DECISION DELEGATED TO HEAD OF PLANNING

Application No: H18-0803-24 **Applicant:** Mr L Petts

Proposal: Demolition of Existing Buildings & Erection of Two Single Dwellings & Four Apartments

Location: 186 Bridge Road Sutton Bridge Spalding

1 Block Plan 1:500

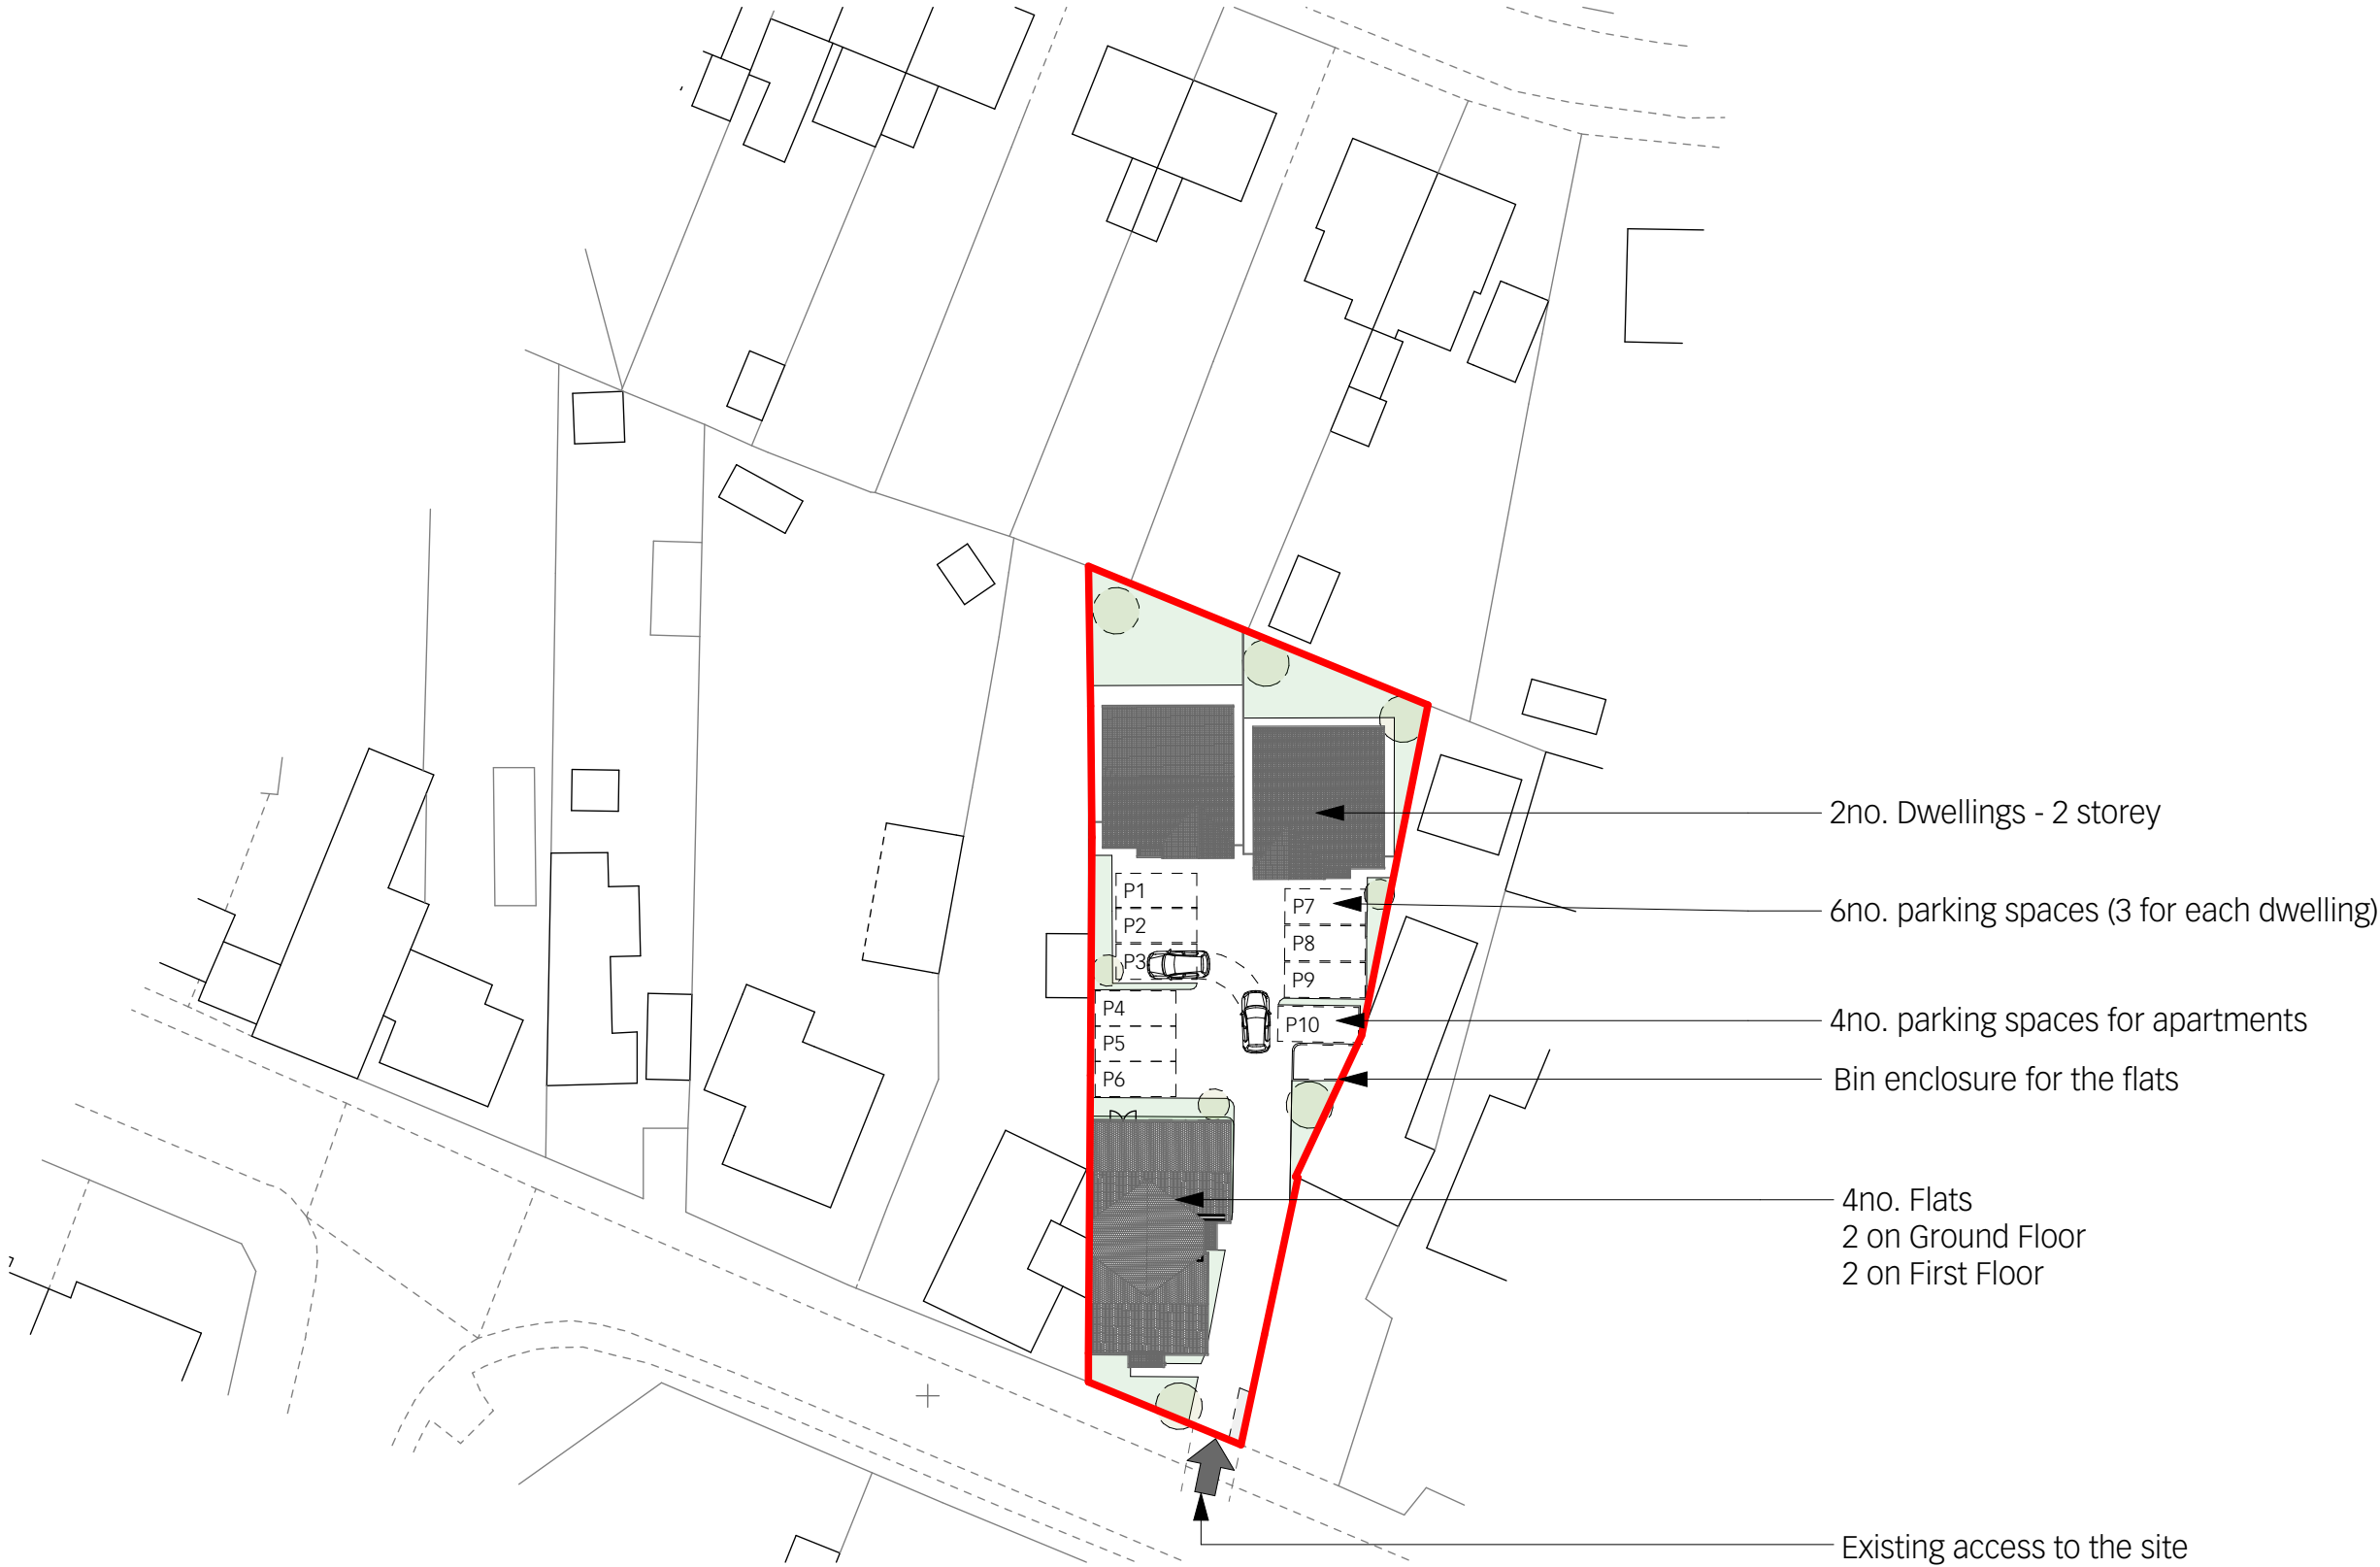
site, next to Bridge Road. The proposed site layout would continue to use this access and extend this towards the rear of the site where 10 parking spaces are proposed for both the dwellings and the proposed apartment building. No dedicated cycle parking is proposed.

Lincolnshire County Council's highways team have set out that not enough parking spaces have been provided. Although six spaces are proposed for the two dwellings towards the rear of the site, only four spaces are proposed for the apartment building. As there are four apartments, the parking standards within the Local Plan set out that two spaces should be provided for each apartment. There is therefore a shortfall in four spaces. This could result in future occupants needing to park on the surrounding streets such as Bridge Road, and this could pose a potential hazard in terms of highway safety.

The highways team have also set out that the proposed access measures 3.75m in width. The access is narrower than this on the submitted block plan within which it measures 3m at the site entrance. The highways team have set out that the access should be a minimum width of 4.1m for the first 10m, to enable the passage of two-way vehicular movements in accordance with Manual for Streets.

Lastly as the access would be a private drive, a suitable storage area close to the access for kerb side refuse collection should be considered, however, this is not shown. This is necessary as refuse vehicles will not enter a private drive.

1 Side Elevation One 1:100

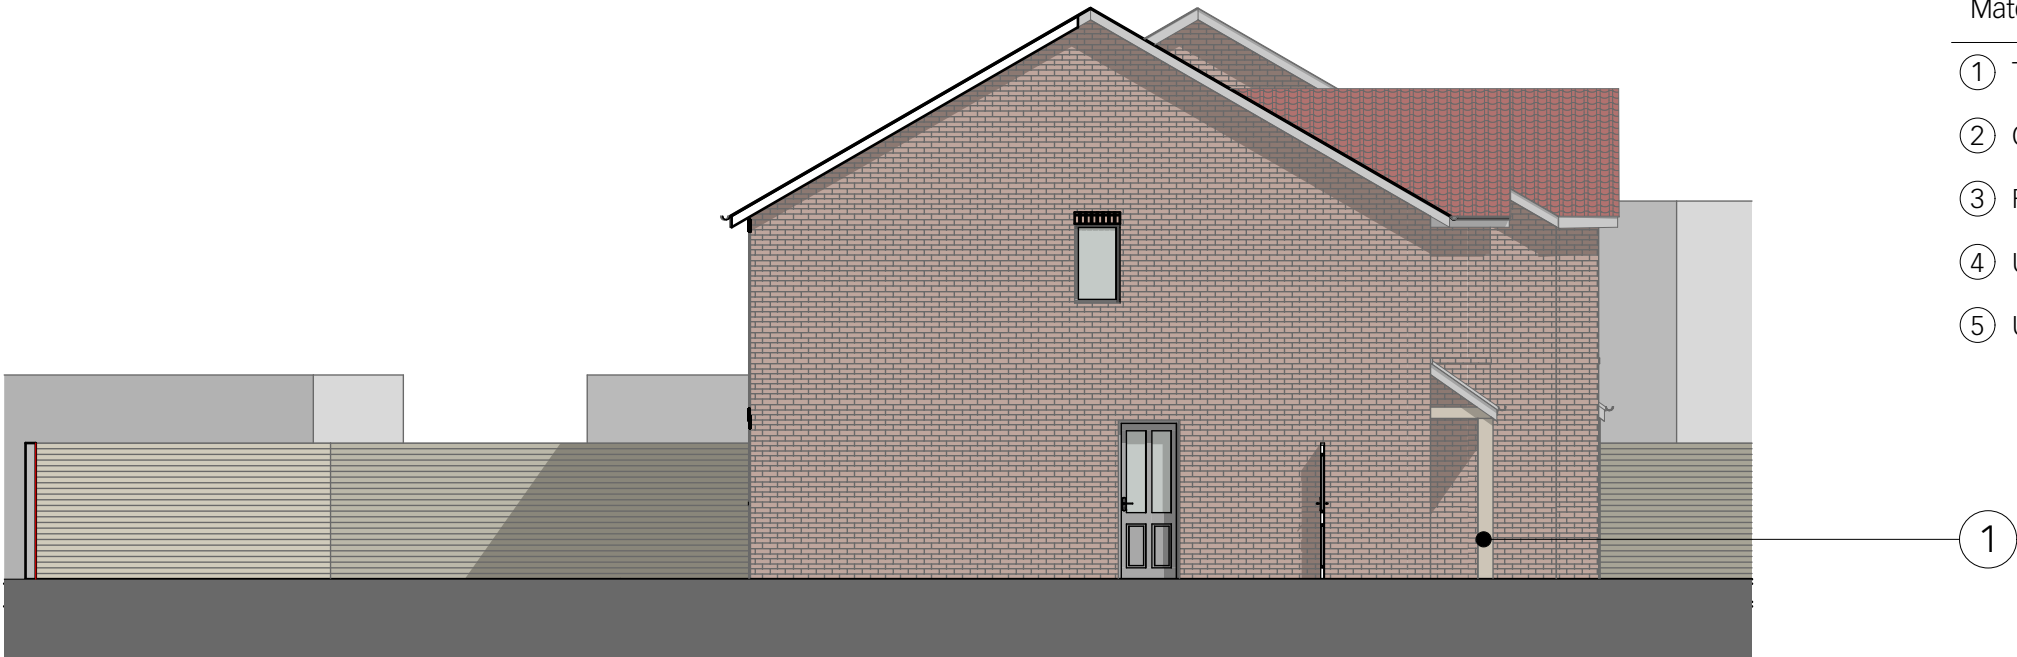
In terms of the proposed dwellings at the rear of the site, the only windows on the side elevations at the first-floor level would connect to bathrooms. These windows would need to feature obscure glazing. With obscure glazing installed, the positioning of these windows would not result in an unacceptable degree of overlooking with neighbouring properties.
